Job Name: Balloon Fiesta Park

Re: Balloon Fiesta Park Sid Cutter's Pilots' Building

The purpose of this resubmittal is to address concerns made in your letter to BHI dated July 21, 2014, and seek approval for Building Permit of the above referenced project. Your comments are restated and addressed as follows:

SITE DEVELOPMENT PLAN FOR BUILDING PERMIT  
SITE PLAN

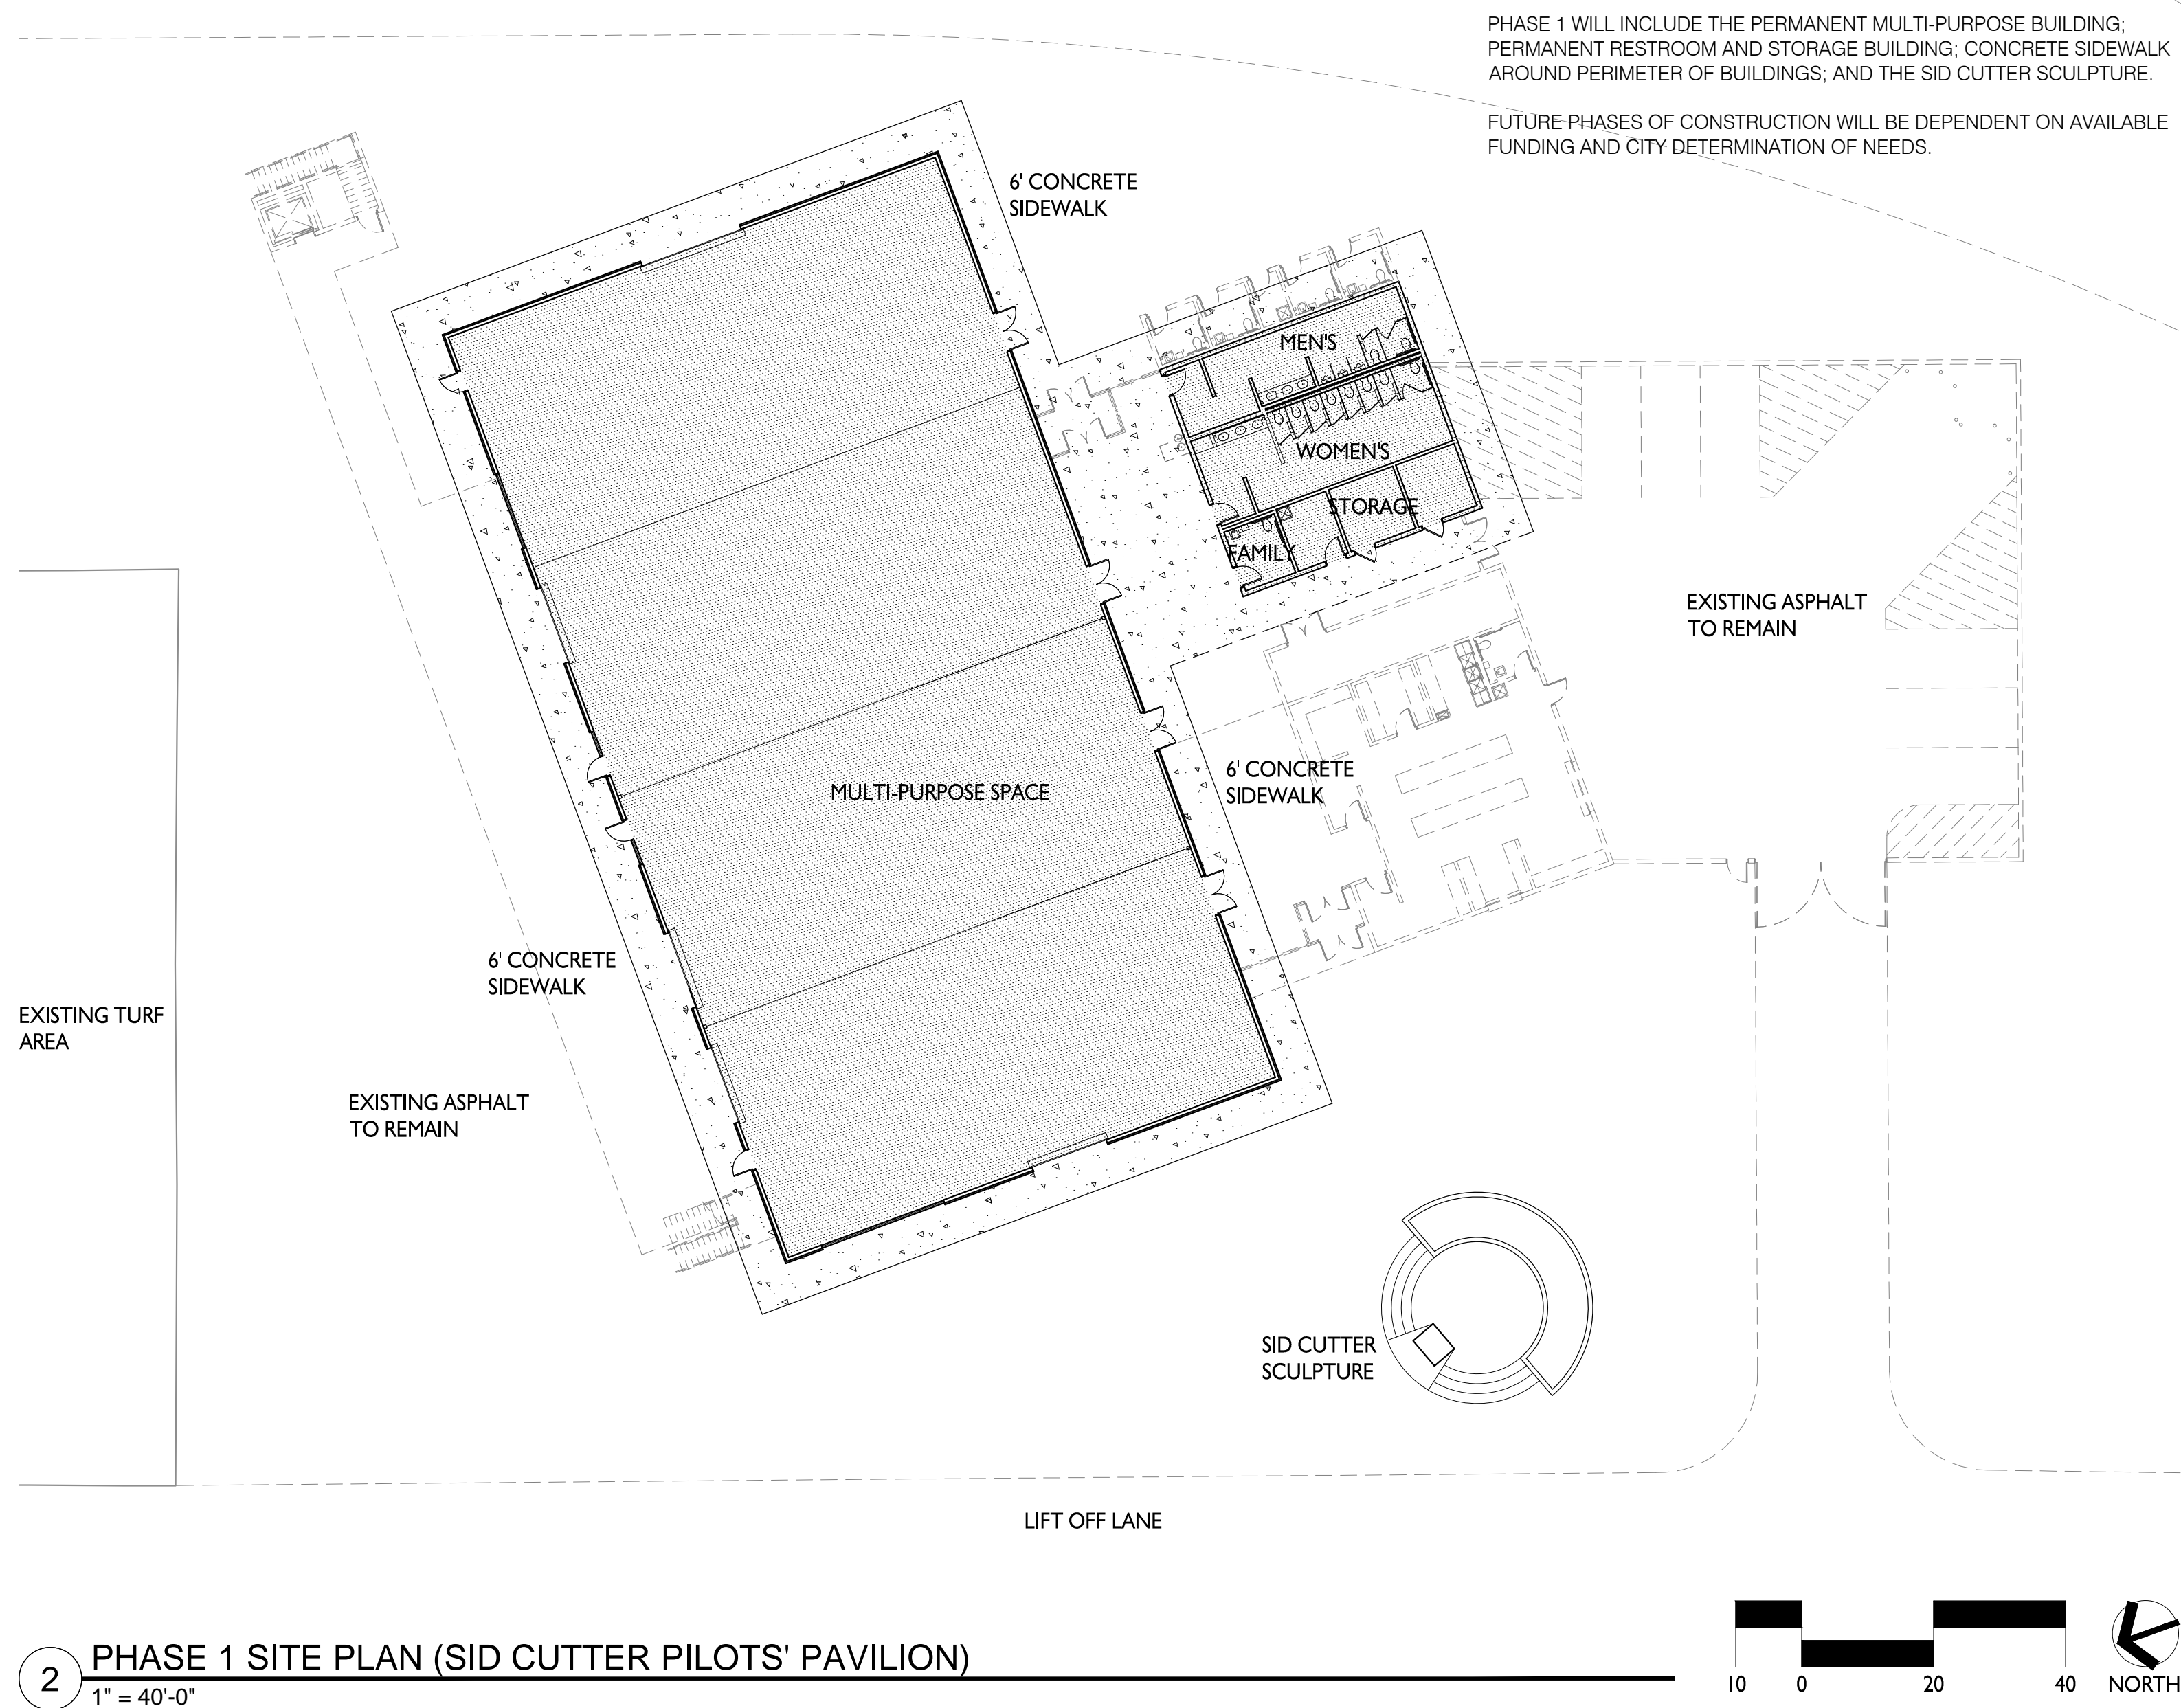
- The building is different especially on the east side from what was approved for Site Development Plan for Building Permit. What percentage of the building has changed? Has the site plan gone in for an Administrative Amendment? You mentioned a second phase being done for this project. Provide a site plan showing the second phase.

- The submitted site plan is attached for your review. It shows the current building layout.
- Show a vicinity map and a FIRM map with the site location. Include a benchmark on the drawing.
